November 6, 2019

Ms. Lindsay Darden
El Paso County Planning and Community Development
2880 International Circle, Suite 110
Colorado Springs, CO 80910

RE: 5401 Fountain Valley School Road
Stealth Wireless Telecommunications Facility
(Verizon Wireless: CSP BIG JOHNSON)

Drawing Revisions (Rev. G, dated 9/26/19):

SHEET TITLE: COMPOUND PLAN		REVISION: E	PROJECT INFORMATION: FOUNTAIN VALLEY CO4714

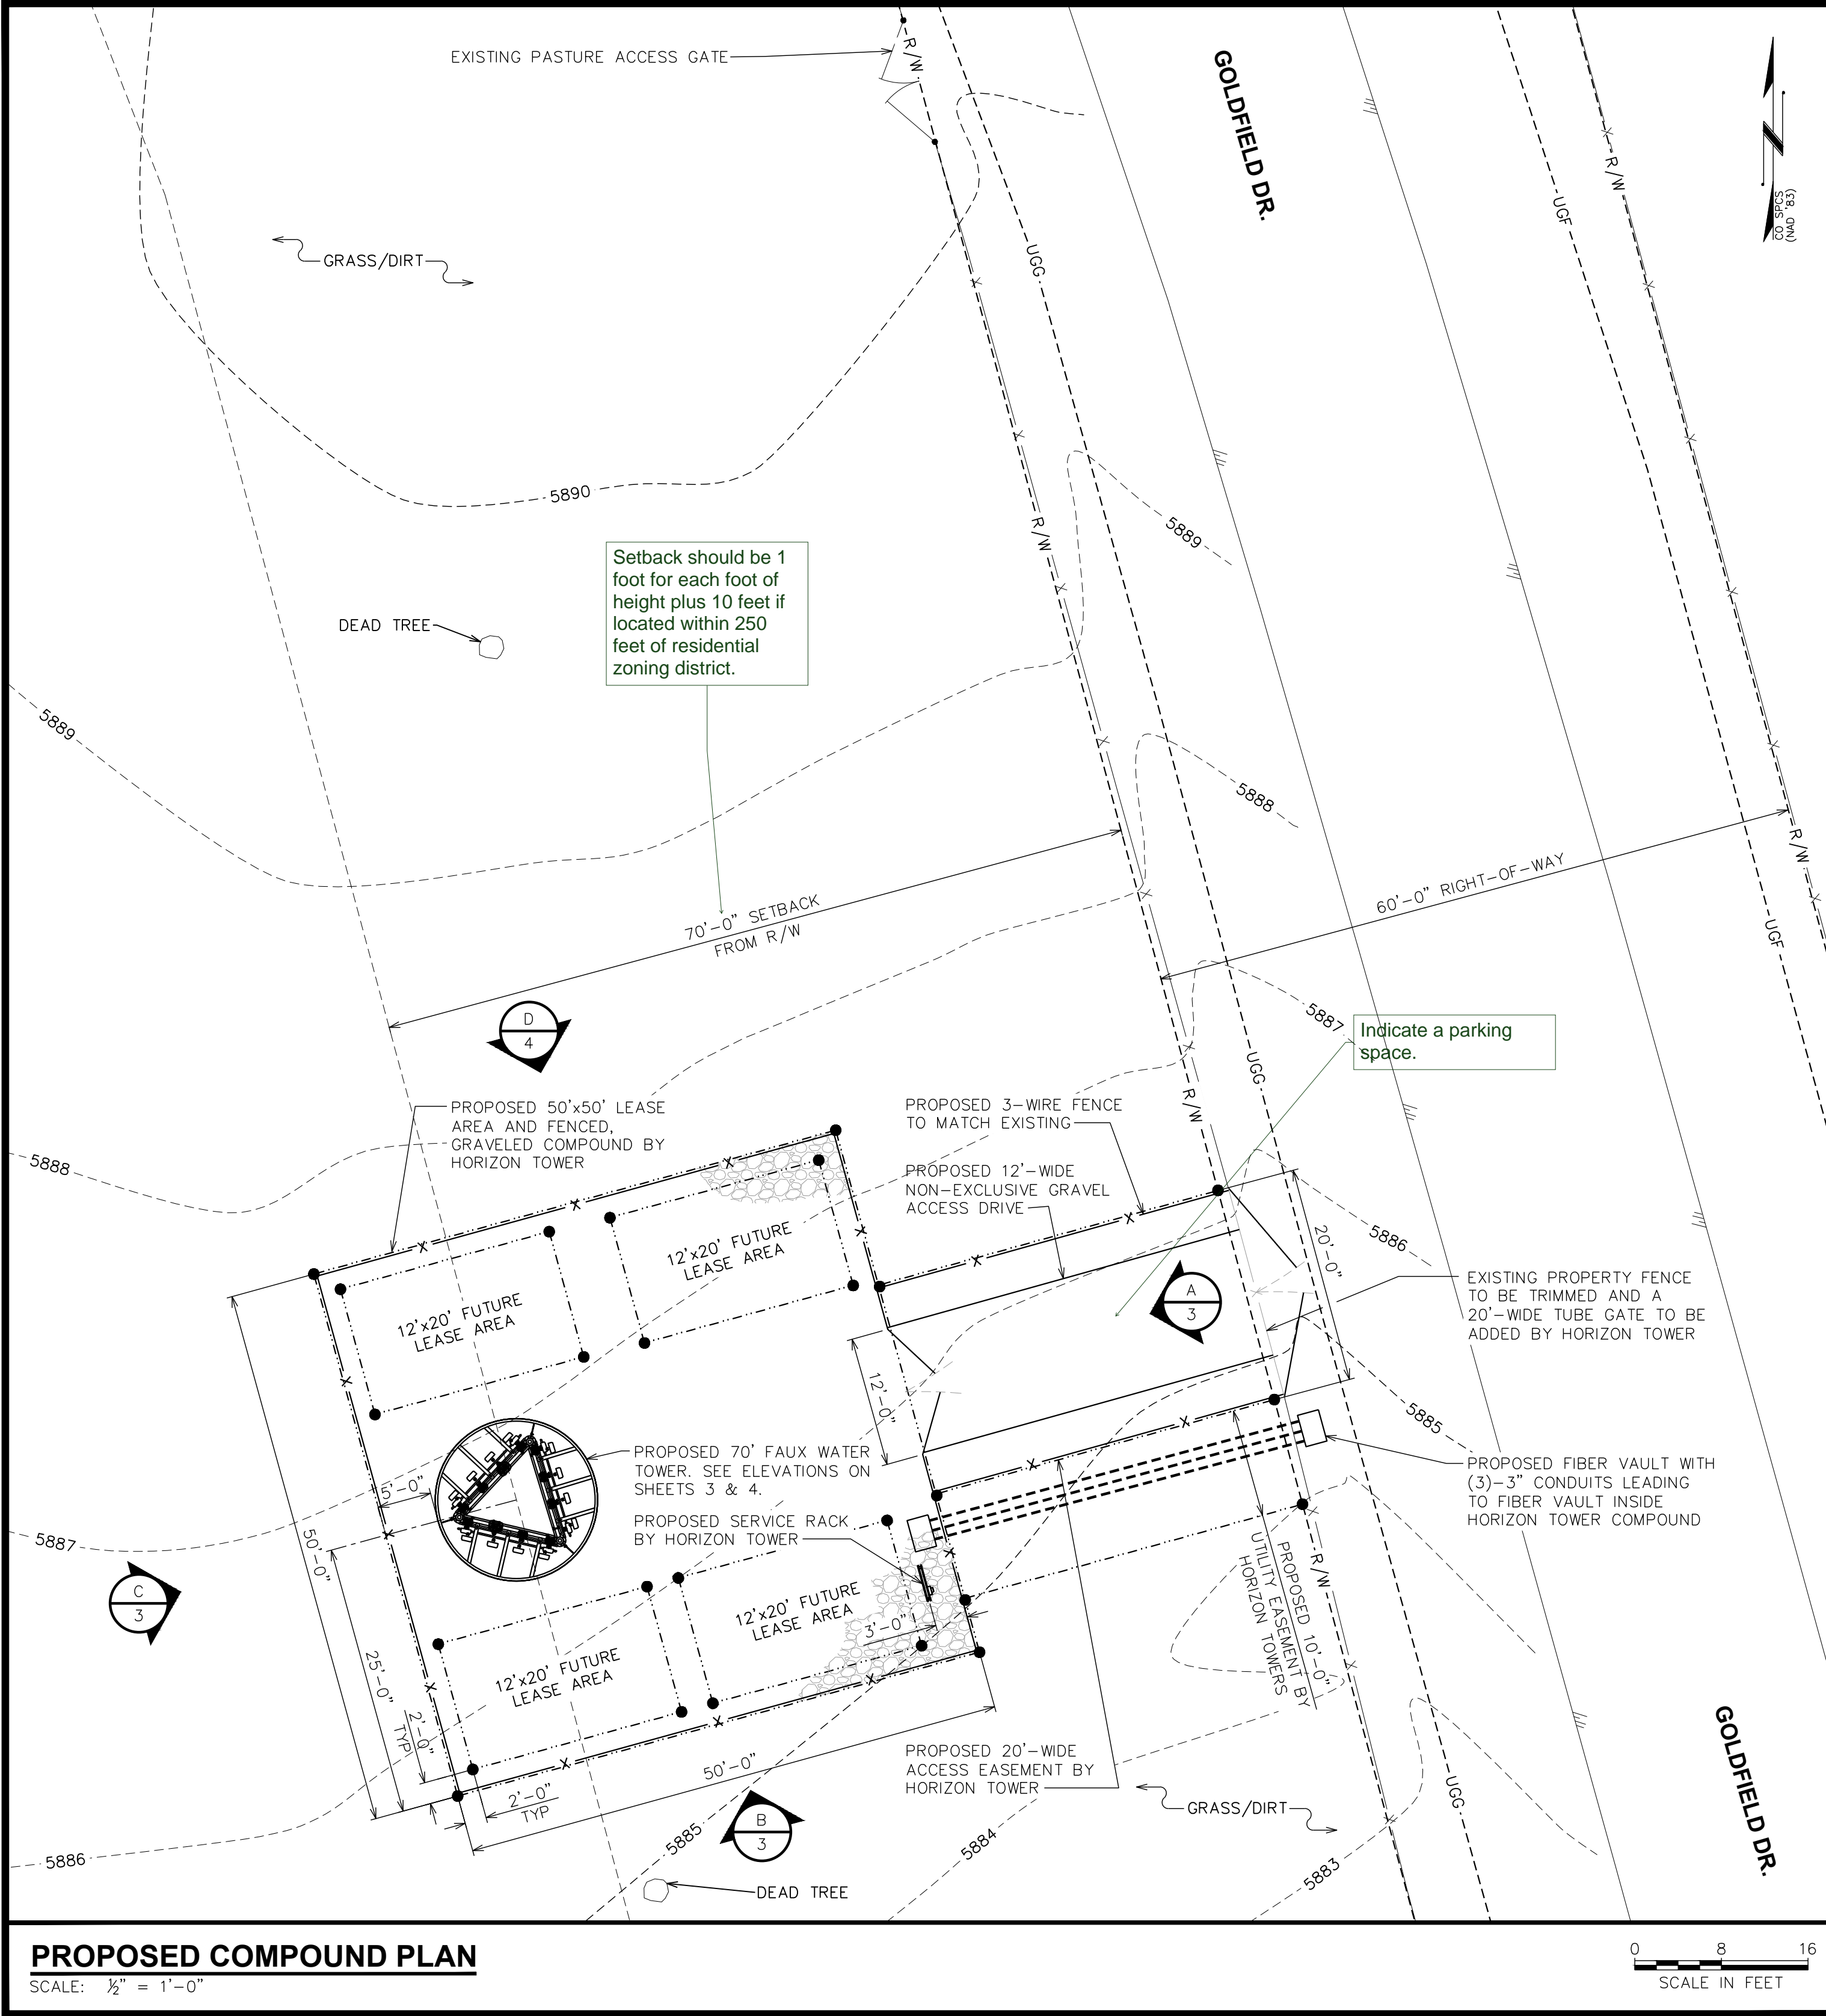
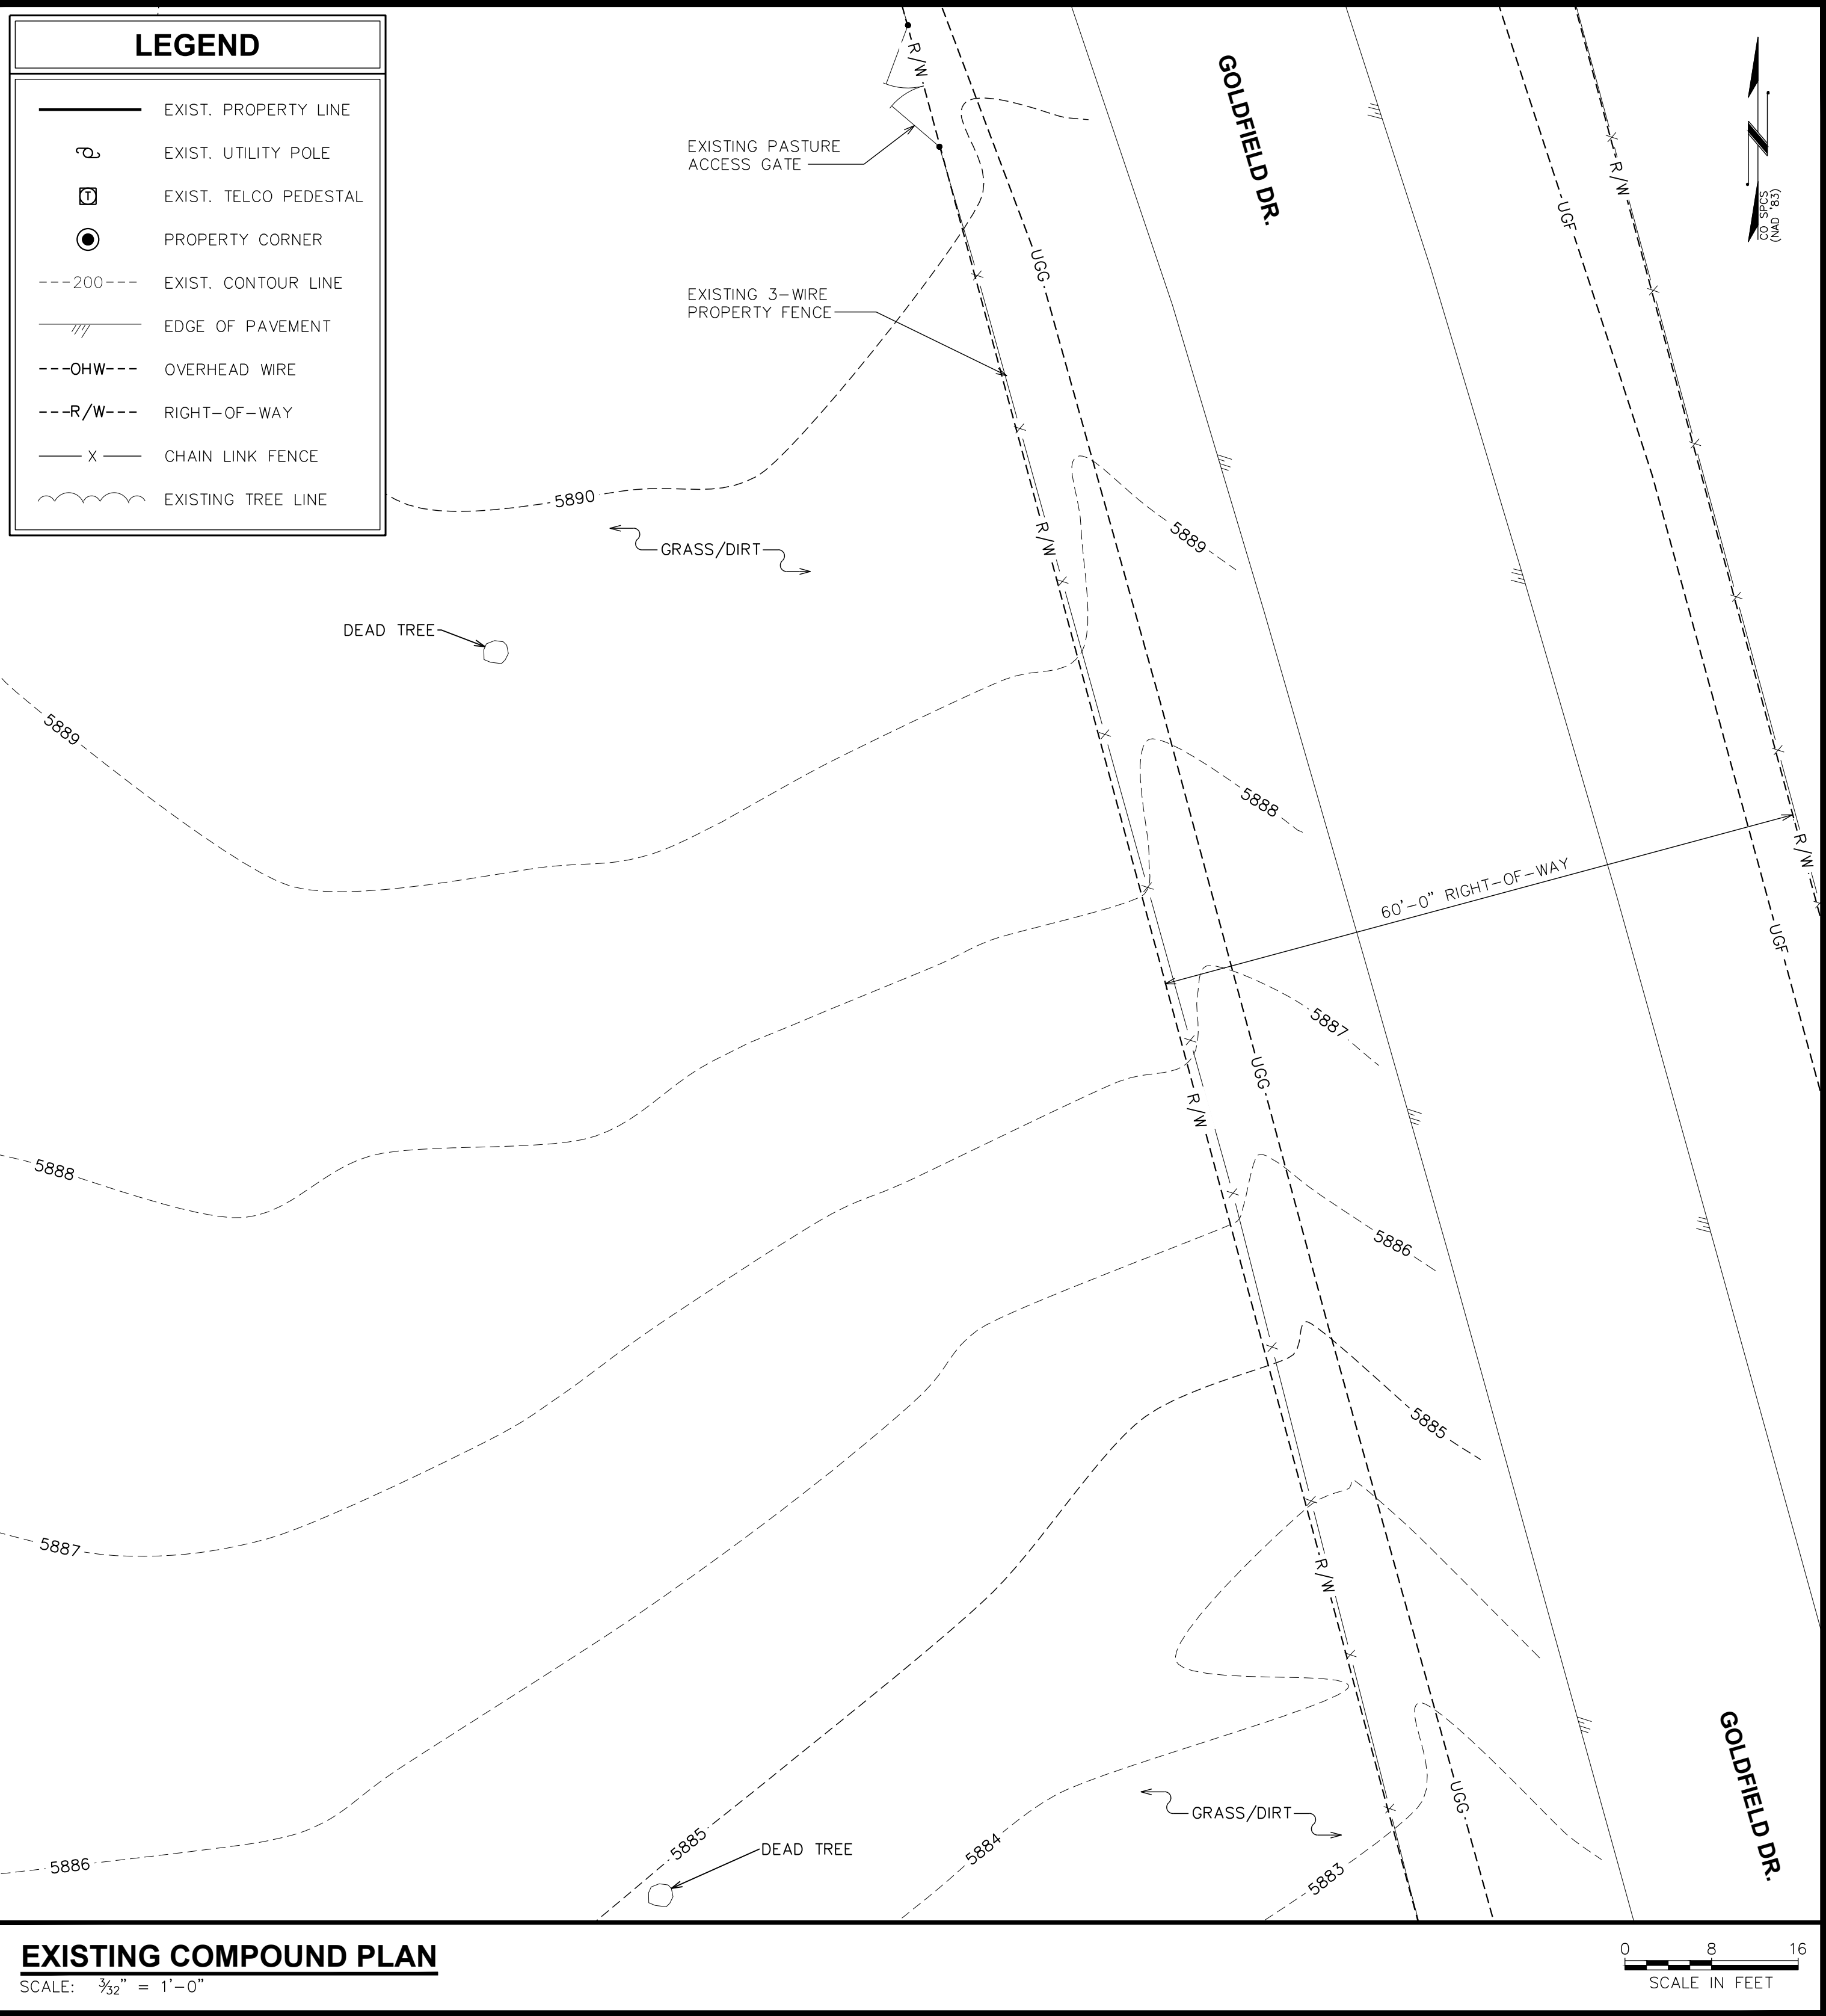
- PCD File Number: AL-19-021 added in the "Project Information" box on Sheet 1, and in Project Information in all page Title Blocks
- Note indicating tower lighting to be determined by FCC added to "Project Description" box on Sheet 1
- Dimension added to "Area Map" defining distance to residential parcel on Sheet 1
- Microwave call outs revised to say they cannot exceed 4' diameter on Sheets 3 & 4
- Fence Detail added into Page 2
- Acreage defined as 937 in "Project Information" box on Sheet 1
